RE: DFT Review Comments for Route 66 Flats (7600 Central Ave SW)
Project Number: PR-2024-009904

On behalf of High Desert Housing and BlueLine Development, thank you for your Site Plan review of the new affordable housing community located at 7600 Central Avenue SW.

Please see the attached comment responses to Plan Review #1, if there are any questions pertaining to the responses, please let us know- Thank you Ed Parcell.

NO. IR100

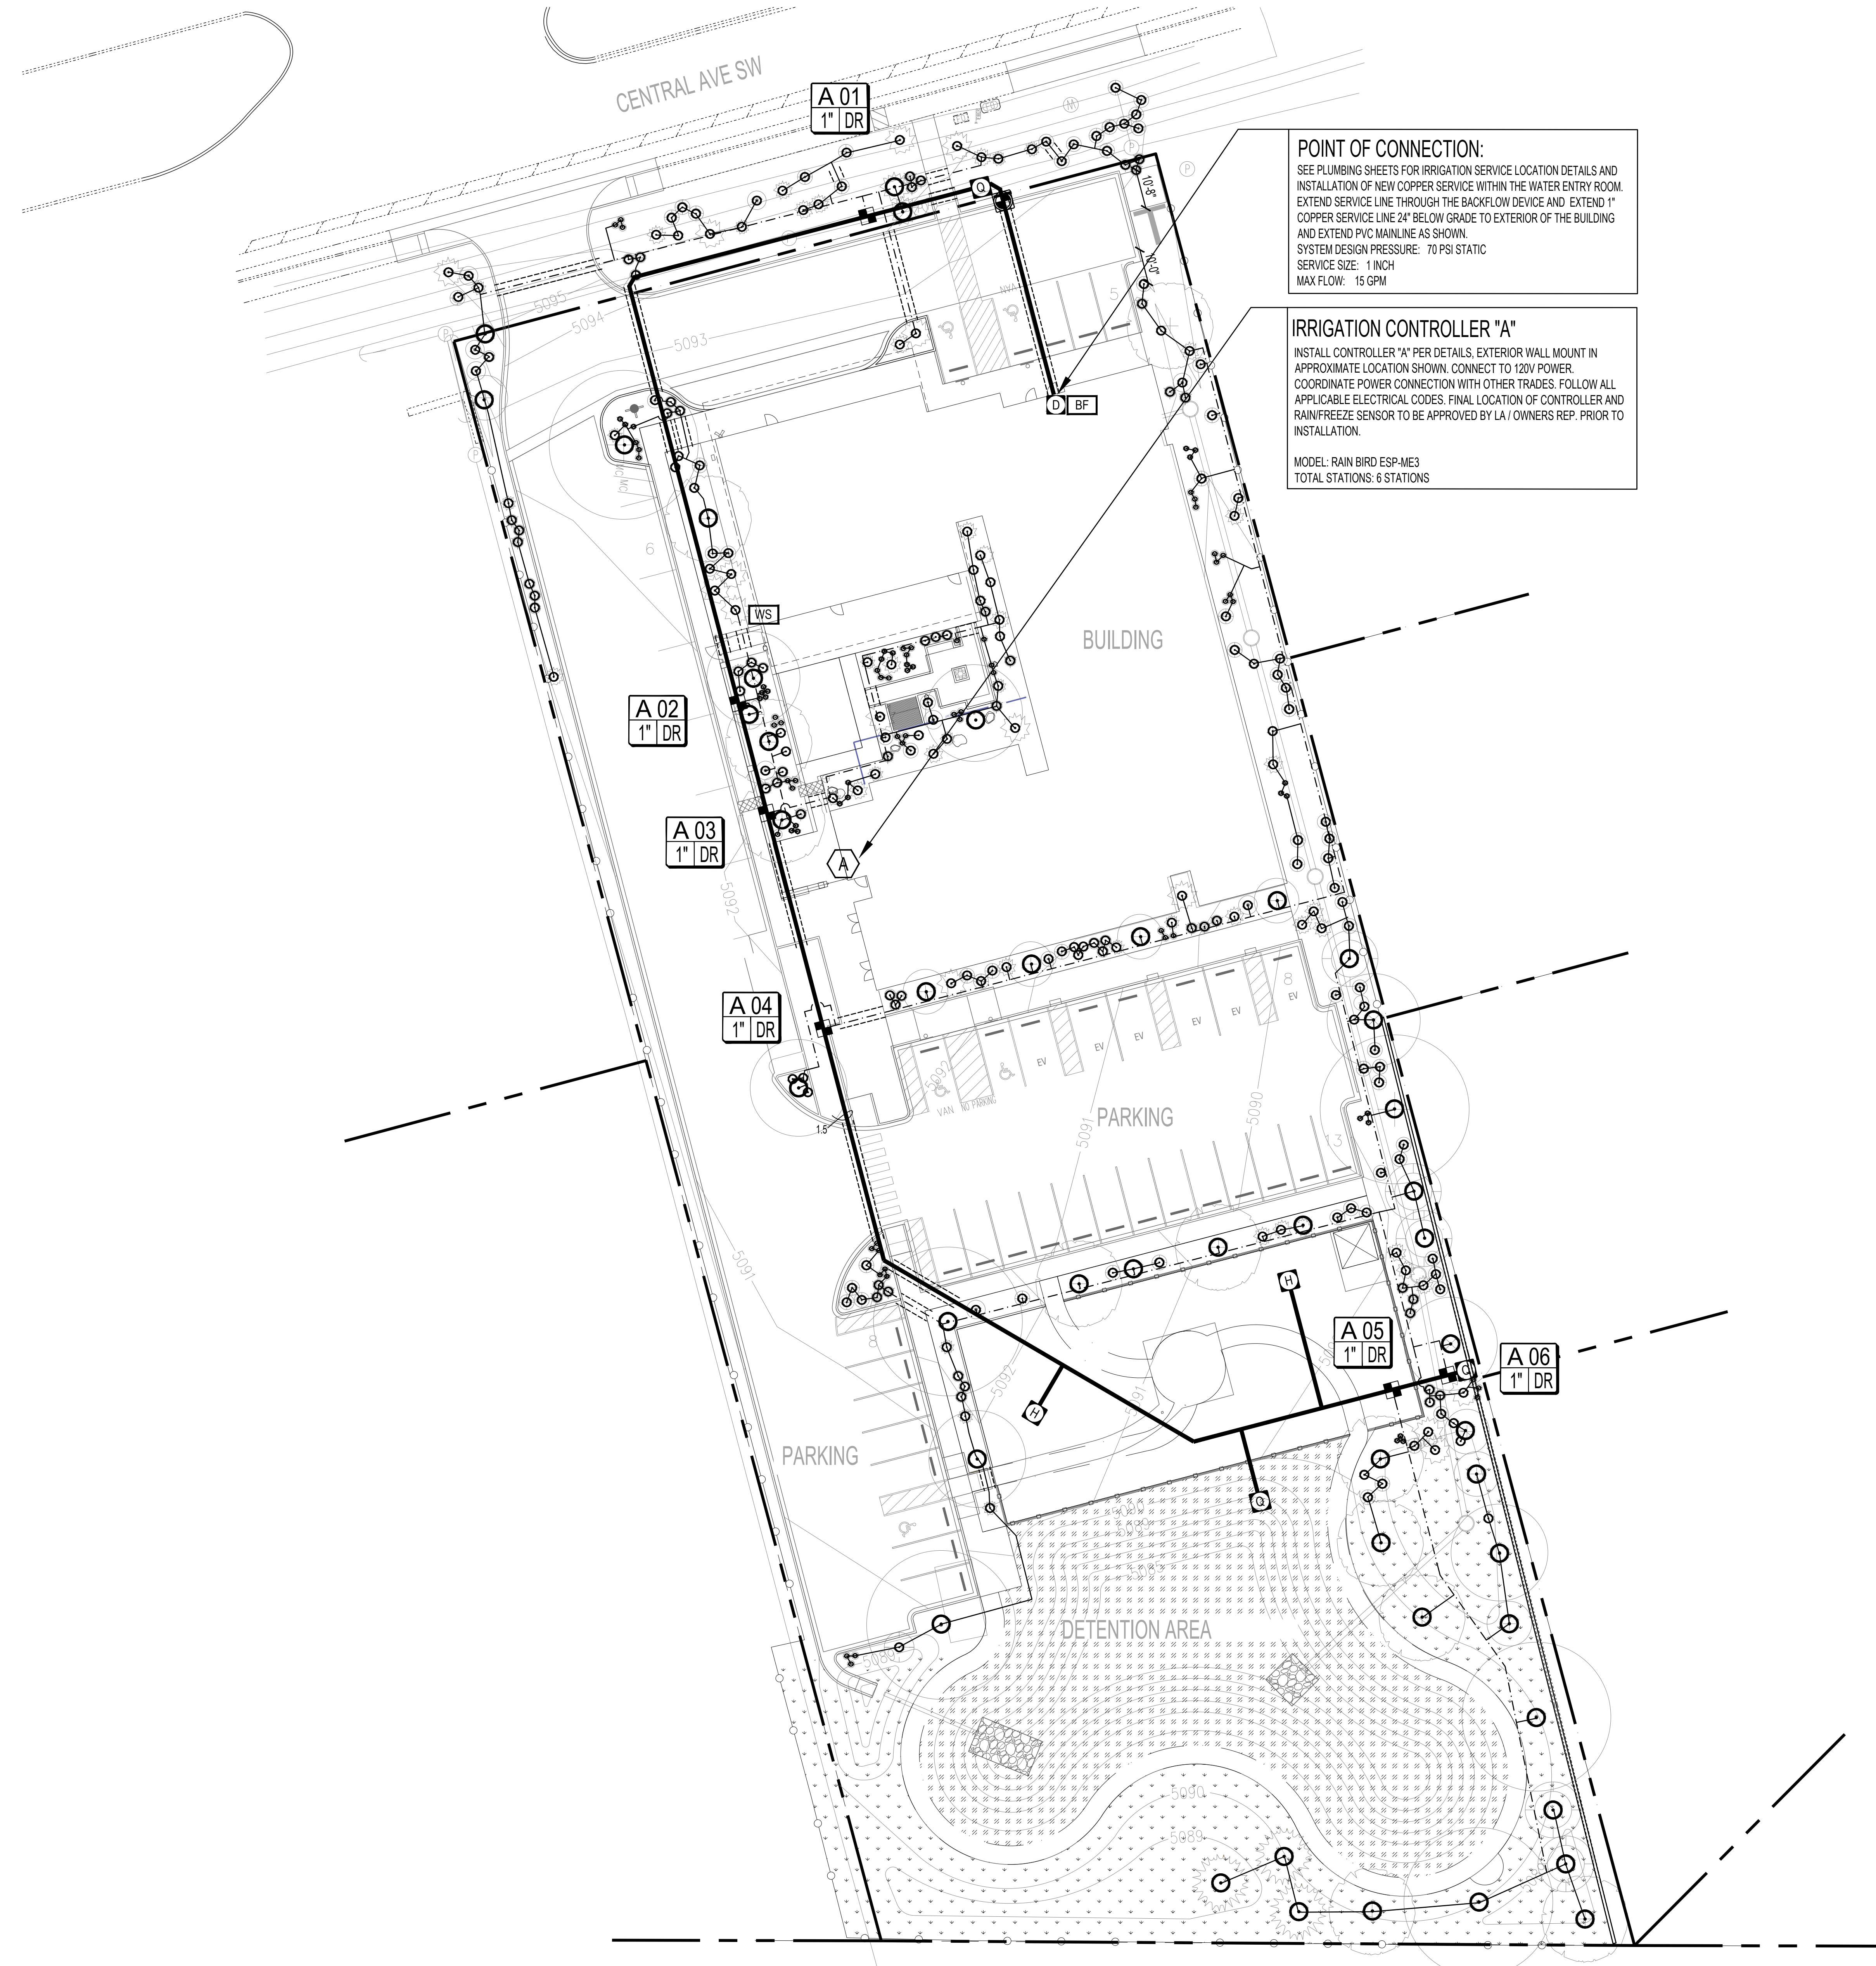
Add the following notes to the Landscape plan **(Flow response): Irrigation notes have been added to sheet IR100**

Add notes to the Landscape plan **(Flow response): Irrigation notes have been added to sheet IR100**

**B6 CENTRAL AVE ELEVATION (FRONT)**  
3/16" = 1'-0"

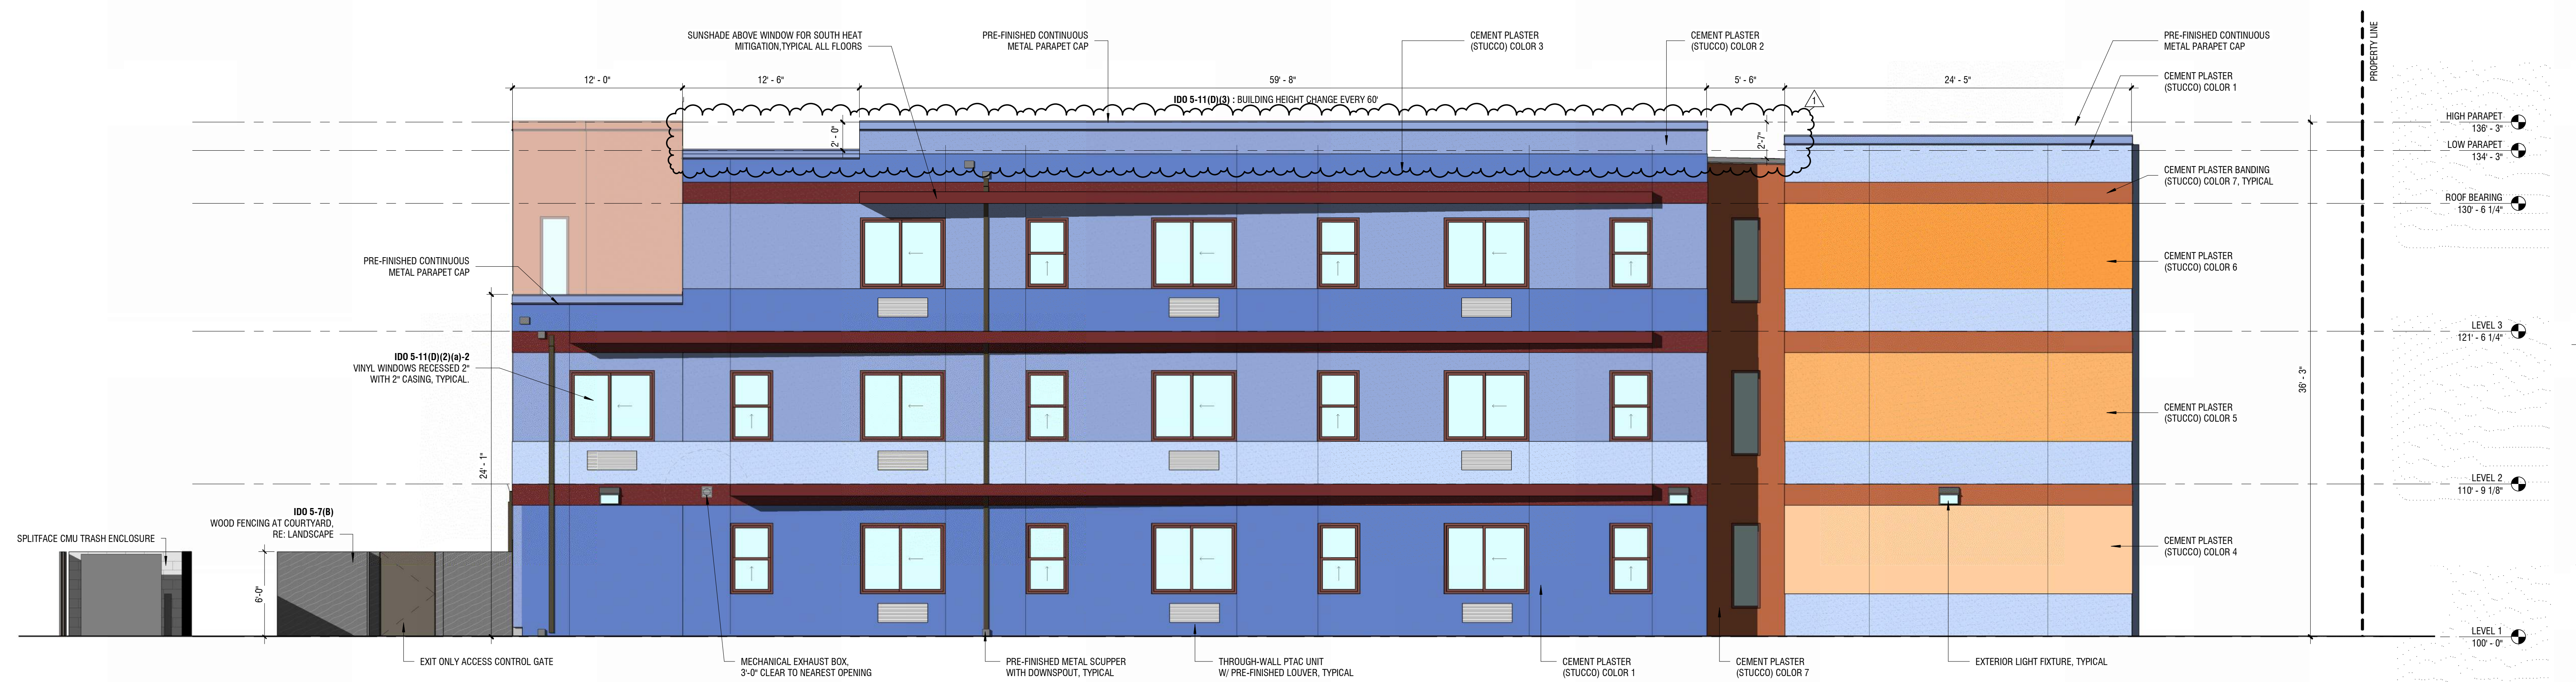
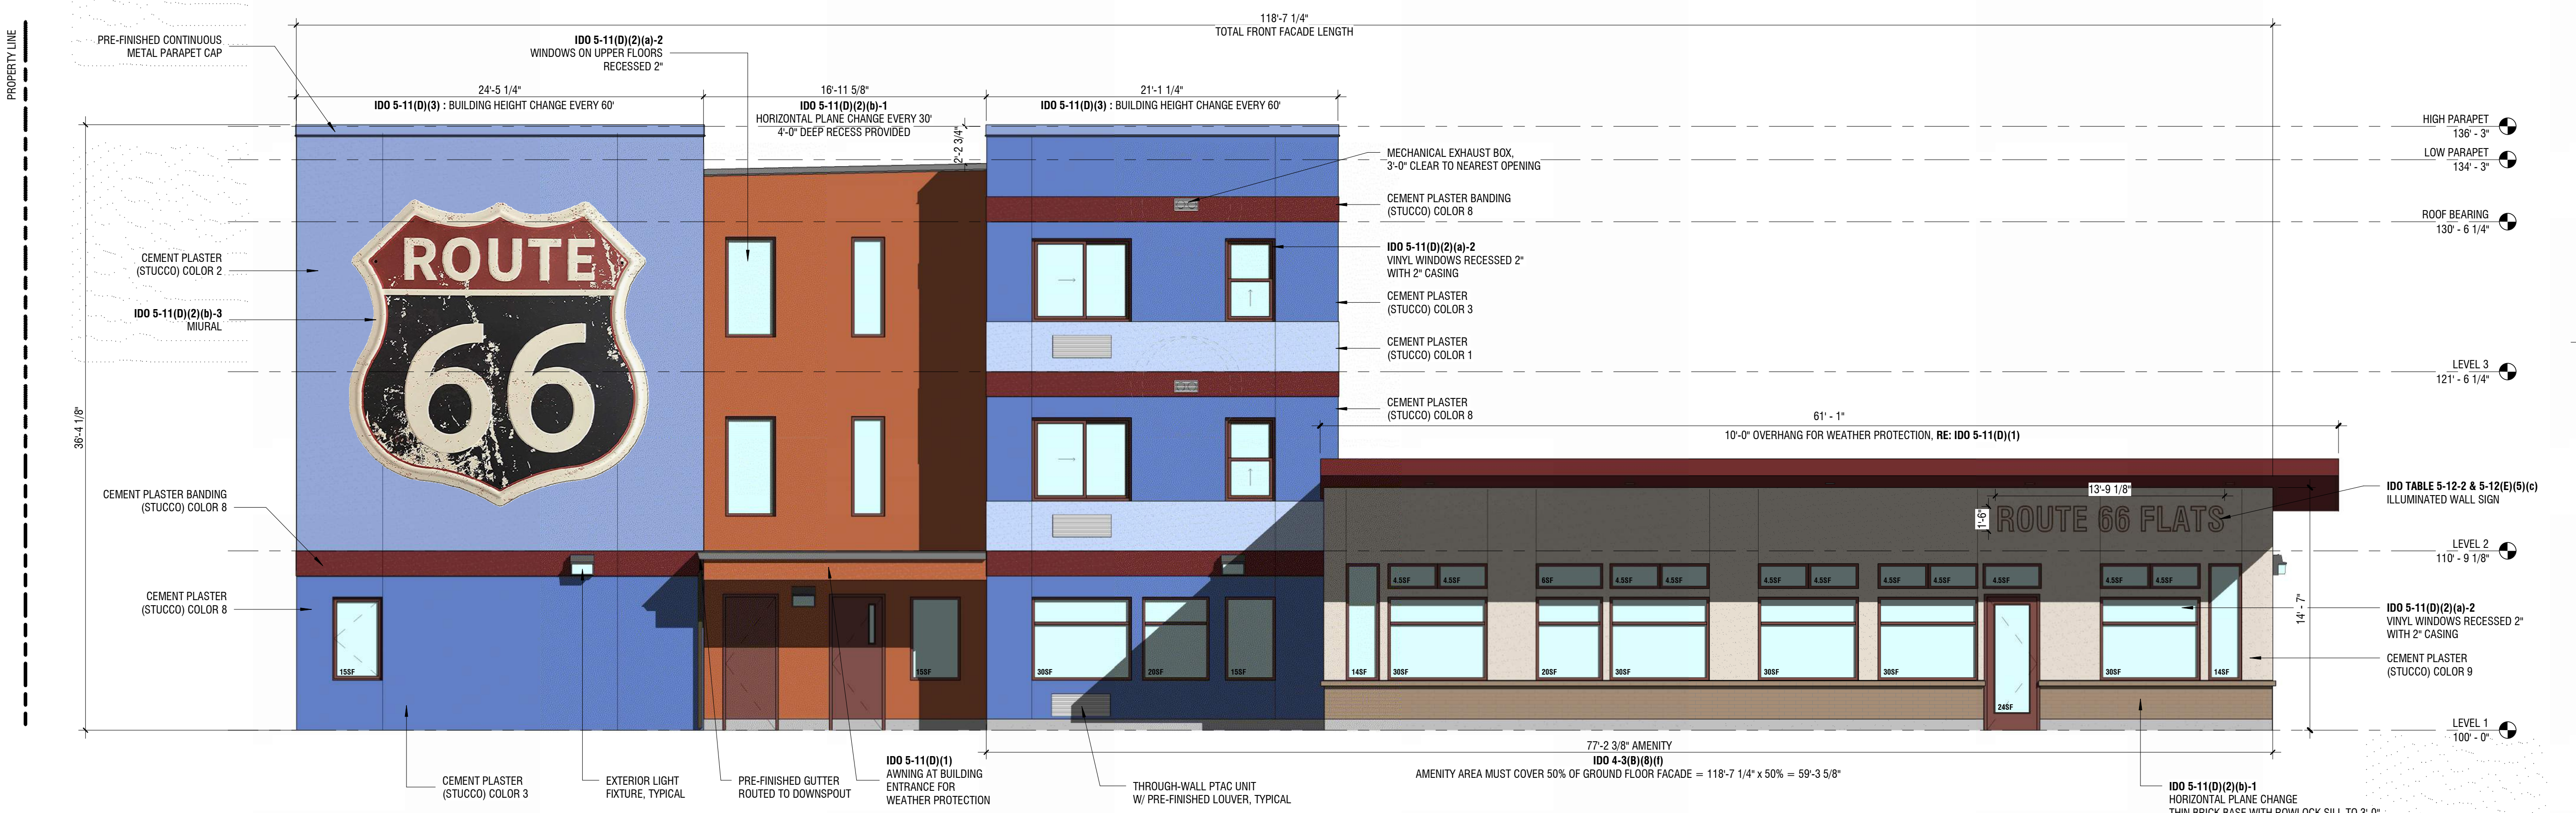
Amenity must cover 50% of the ground floor front façade per IDO 4-3(B)(8)(f), ***(SW Response): current design meets standards, calculations added to front elevation***

4-3(B)(8)(f) In any Mixed-use zone district west of the Rio Grande on properties abutting the public right-of-way of a Major Transit or Premium Transit Corridor, allowable uses in the Commercial category are required along at least 50 percent of the ground floor of the façade facing the Major Transit or Premium Transit Corridor. **(SW Response): calculations added to plans to show compliance.**
